From: Peter Boyes [Peter.Boyes@hyndburnbc.gov.uk]
Sent: 17 August 2011 15:18
To: Colin Sharpe; planning
Cc: MatthewR@rsolicitors.co.uk; 'jks.windyarbour@talktalk.net'; 'catherinewomack@hotmail.co.uk'; 'jeannaaaron@btconnect.com'; 'Mary.Harwood@lancashire.gov.uk'
Subject: 3/2011/0611/P Hill Top / Blue Trees Copster Green Salesbury

drawing title:
 PROPOSED SITE PLAN

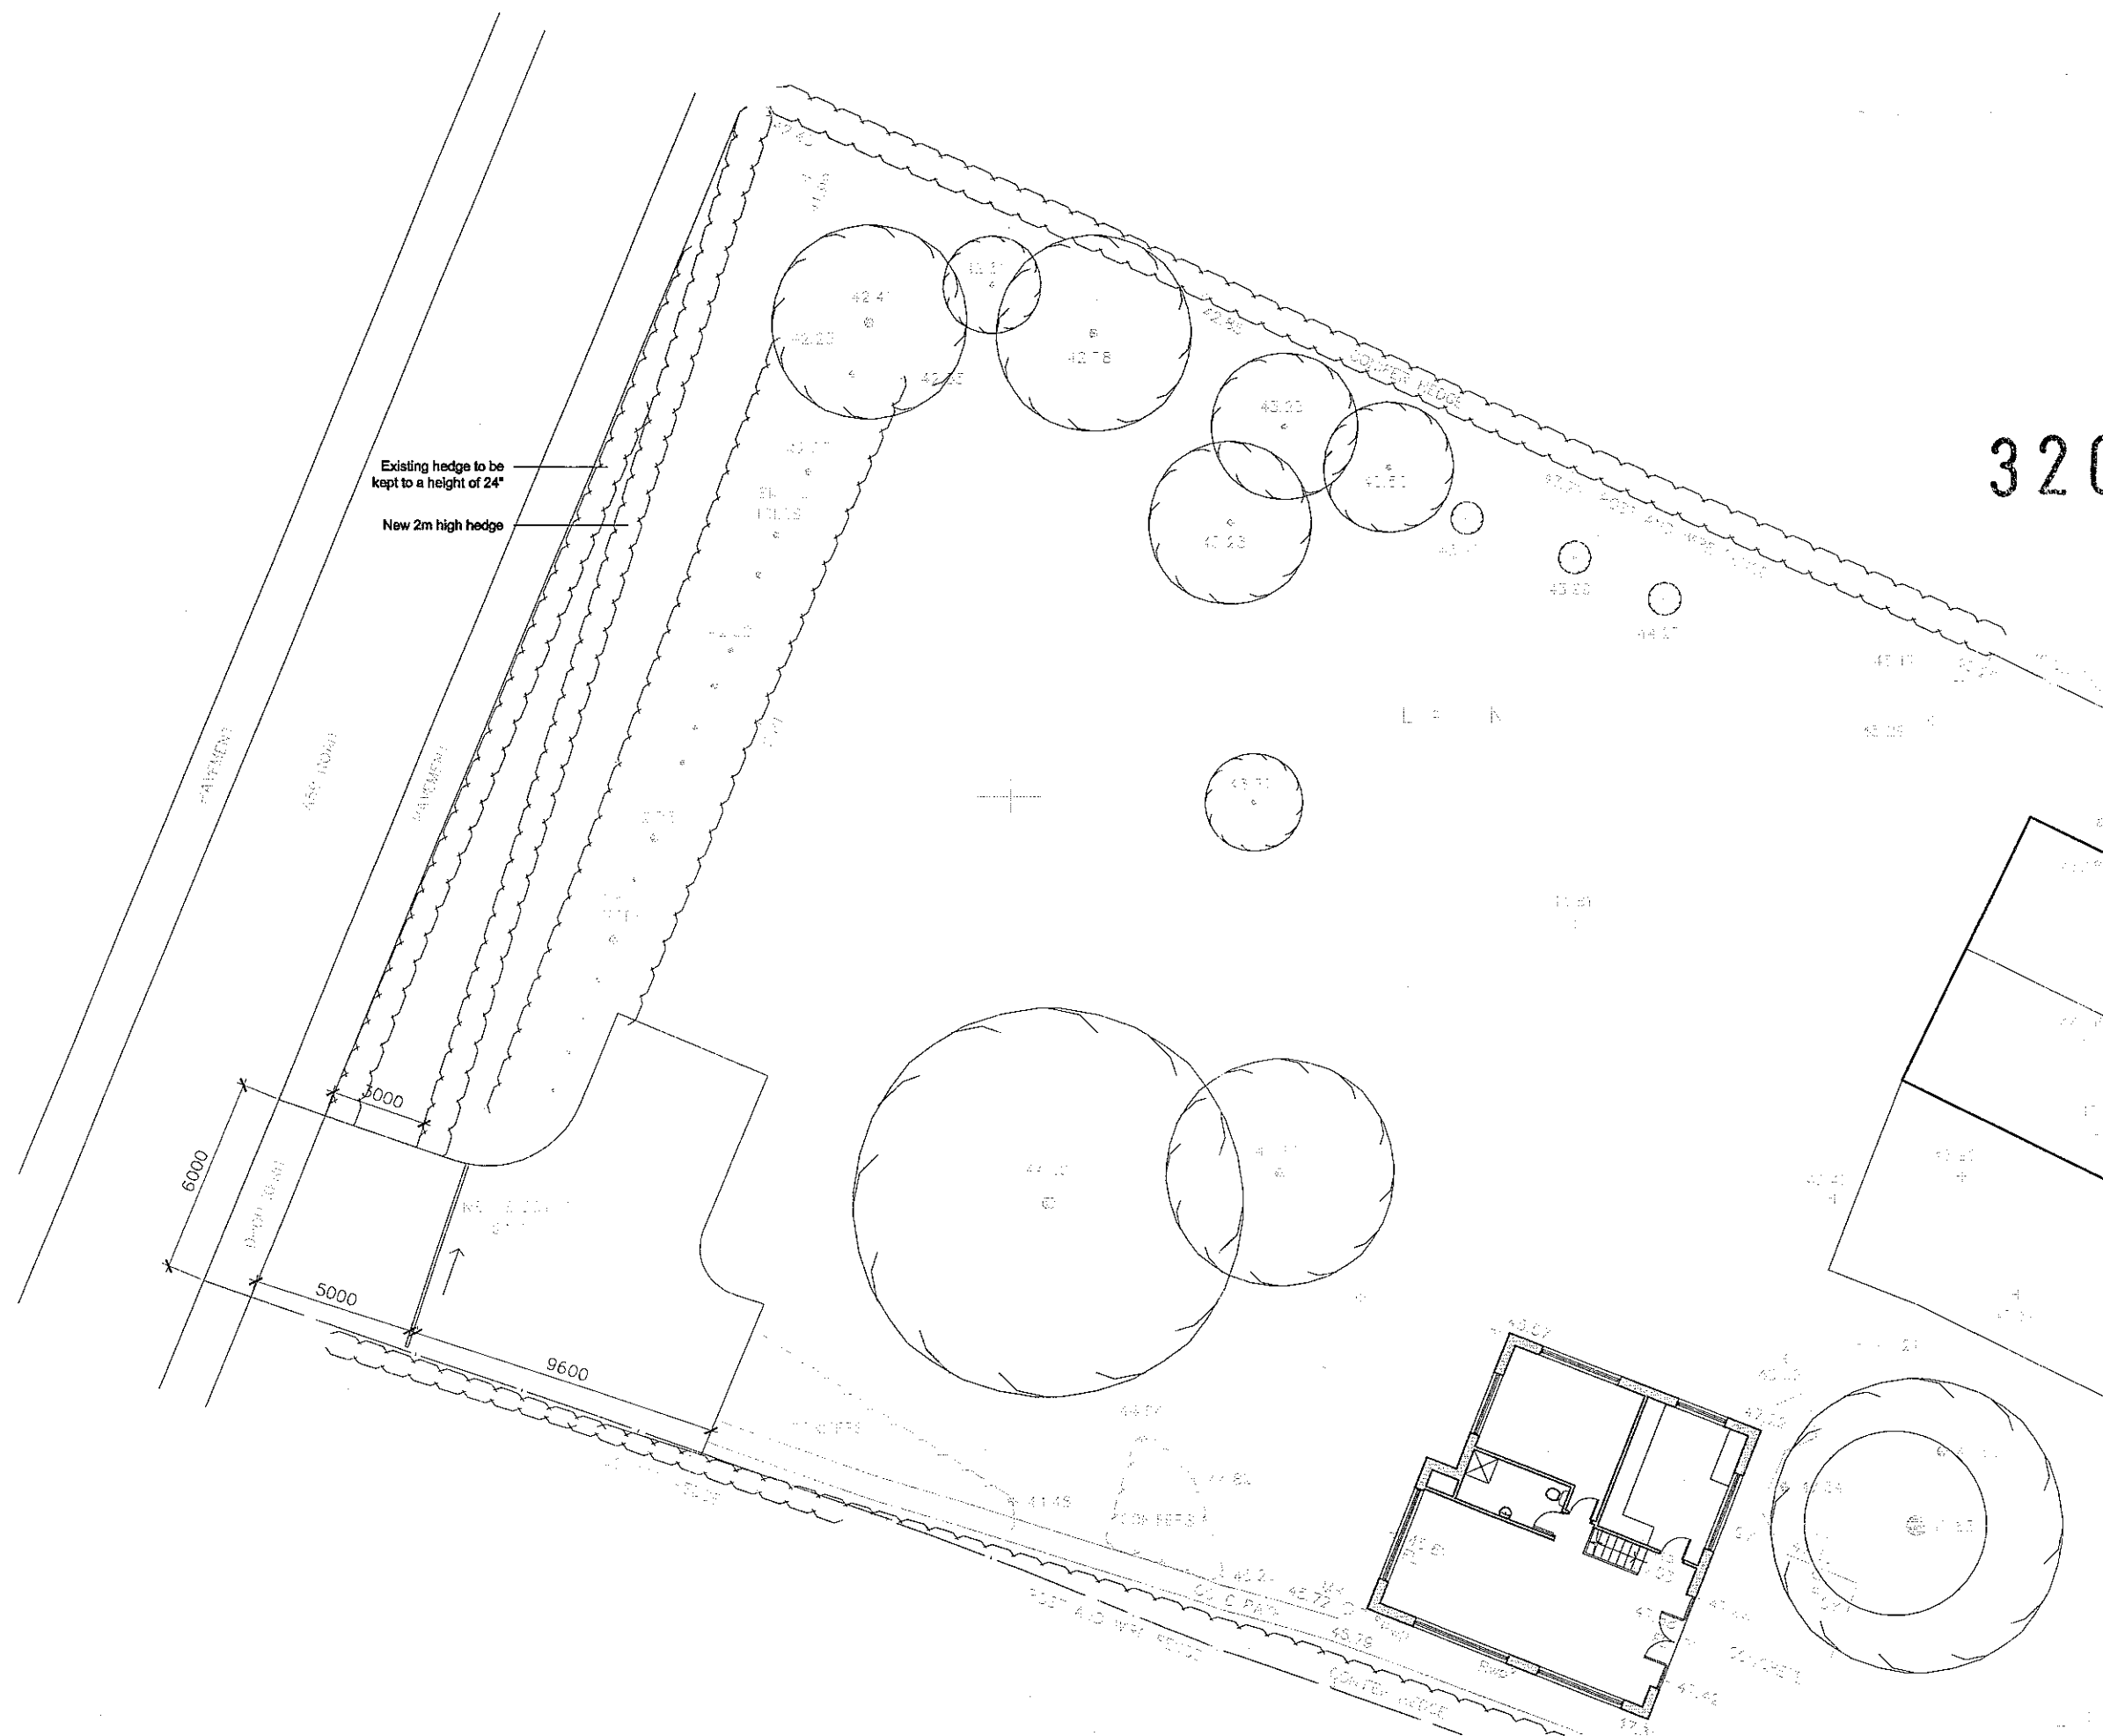
- The planned new access from the A59 falls almost exactly between two speed cameras, which would indicate a potential traffic black spot. Permitting this application will only serve to increase the risks to pedestrians and vehicle users along this stretch of road.

- Please bear in mind that there are two bus stops in very close proximity within metres to the proposed access point, these bus stops and crossing points being used on a daily basis by school children. The proposals would represent a further significant safety hazard.

- There appears to be no requirement or need for a new access from this particular property or site other than to increase the development potential of the large garden area. There are already 3 access points from the site in the applicants ownership (pedestrian access to the A59 and two onto the bridleway accessed from Copster Green Common. All remaining nearby property access points are long established, at safe points and wide fields of vision. The proposed access is at an adverse camber in the road viewed towards Clitheroe.

- The proposals show that the existing 2.4m high hedge (approx.) will be reduced to 24" with a further 2m high fence being introduced to improve the sight line. Who will ensure that this will be maintained as hedges do tend to increase in height, density and width, therefore the maintenance of these proposals cannot be guaranteed. there is no certainty that even the level of visibility provided for in the application will in the longer term be met.

- The sight line length shown for a 40mph speed limit would appear to insufficient. The A59 is a heavily trafficked through route with a speed limit of 40mph (approx. 64kph) and the proposed access will be situated inside of, and towards the end of a bend in the carriageway. **The developer proposes a visibility splay of approx. 3m x 40m to the right when egressing from the access; no provision is made for visibility for the left.** I understand guidance for standards for visibility splays are set out in Dft Manual for Streets and in Design Manual for Roads & Bridges (DMRB). The manual for streets is in general applicable to the design of lightly trafficked residential roads (and in some cases high streets and lightly trafficked lanes in rural areas) so that in this case the guidance given in DMRB is more appropriate. Even so the guidance in

Manual for Streets is that for a speed of 60KPH a visibility splay of 2.4m x 60m is appropriate.

Guidance given in DMRB suggest that a visibility splay of 2.4m x 90m should be sought.

-
- There also appears to be no consideration with regards to the sight line looking towards Preston. What is to prevent the owner of Westholme placing a 2m high hedge or fence along the common boundary obstructing the visual field onto the highway. Therefore adequate sight lines looking towards either towards Clitheroe or Preston cannot be achieved.
